Recommendation Report for Planning Permission

REF NO: P/86/20/PL

LOCATION: Bowley Farm
Bowley Lane
South Mundham
Chichester

PROPOSAL: Retention of 4 No. mobile homes for countryside workers together with drainage & service connection provision in connection with permission P/72/09 as varied by P/22/17/PL. This application is in CIL Zone 5 (Zero Rated) as 'other development'.

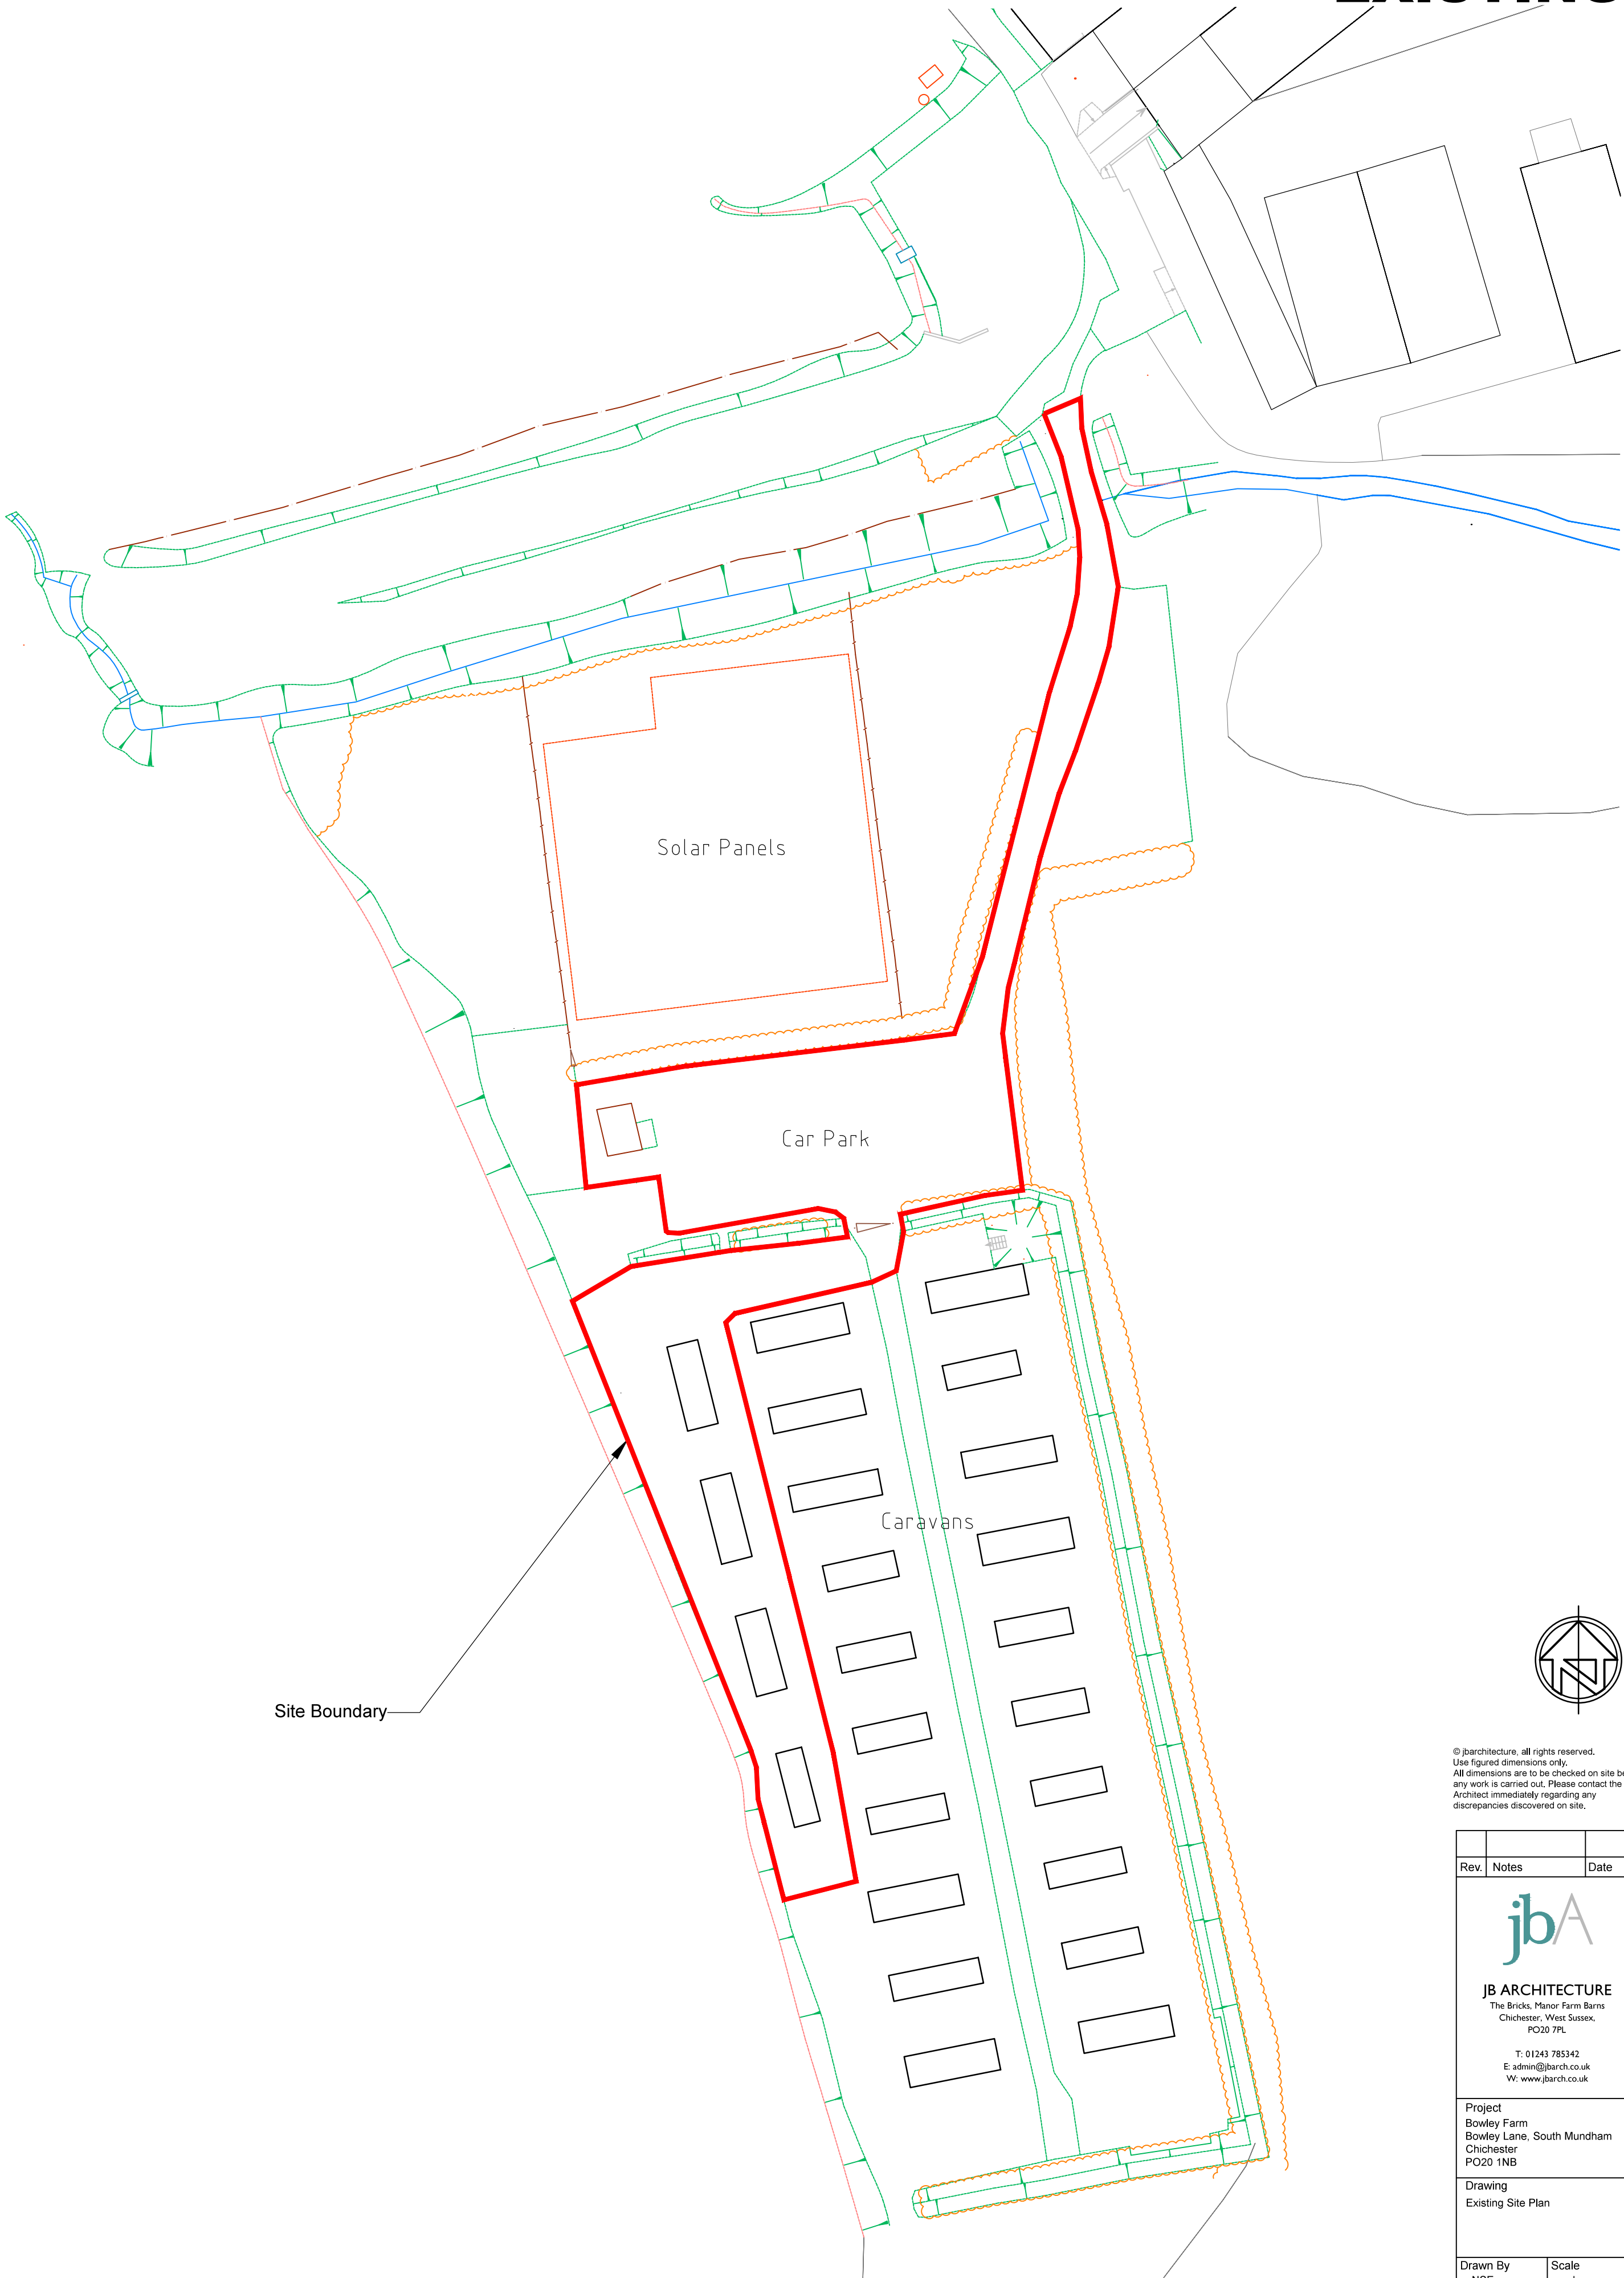
The proposed 4 mobile homes, subject to this application, are located in the buffer zone alongside the watercourse (min 5m wide measured from bank top for the whole extent o the site) which should be without structures, footpaths and should not include formal landscaping. This is the requirement of the Environmental Agency in line with s.23 of the Land Drainage Act 1991 and s. 109 of the Water Resources Act 1991 to protect the adjacent watercourse and land alongside watercourse with its wildlife. As mentioned in the advisory information of the Environmental Agency, water voles have been previously recorded in close proximity to existing ditch network.

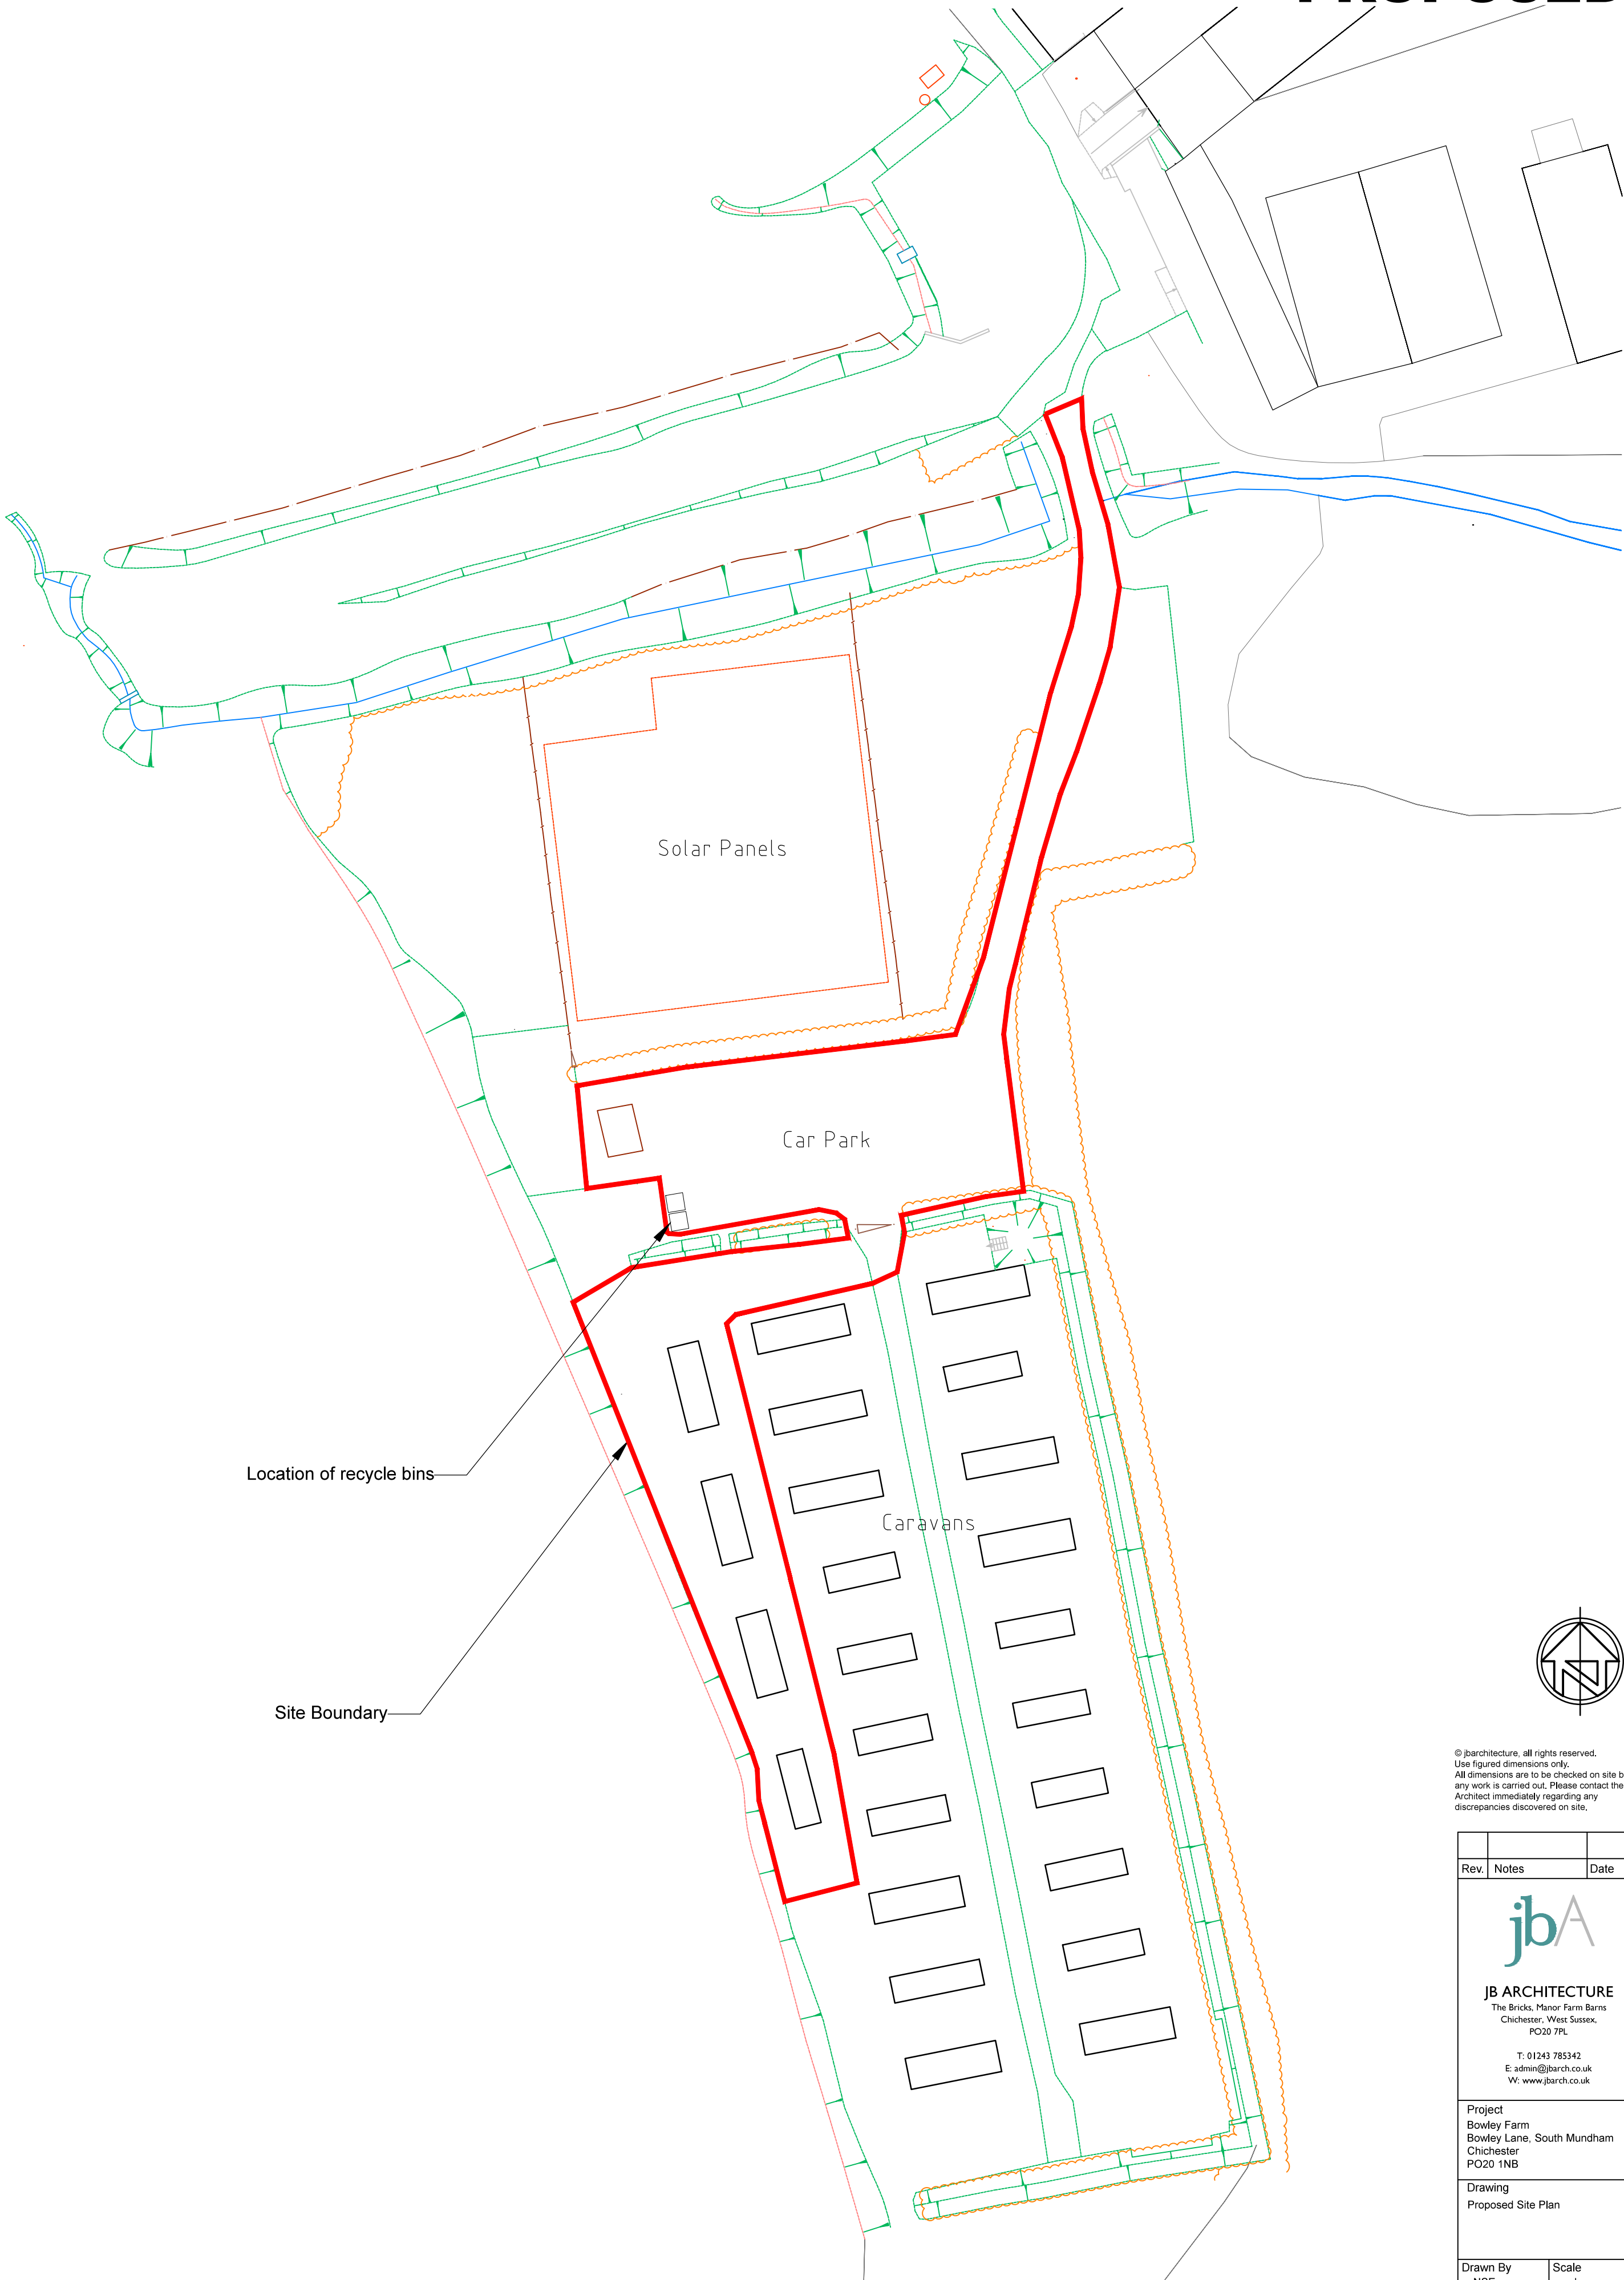
Therefore these 4 mobile homes due to their position within the defined buffer zone are the potential threat to groundwater pollution and disruption or loss of the protected species. Contrary to the Arun Local Plan policies W DM1, ENV DM5 and H DM3 and paragraph 175(a) of the National Planning Policy Framework.

- 2 The 4 mobile homes are in a buffer zone (approved by P/72/09) alongside the watercourse which should be kept without structures, footpaths and formal landscaping to protect the watercourse and the wildlife. The proposal represents a threat to groundwater pollution and disruption or loss of the protected species, in conflict with policies ENV DM5, H DM3 and W DM1 of the Arun Local Plan and paragraph 175(a) of the National Planning Policy Framework.
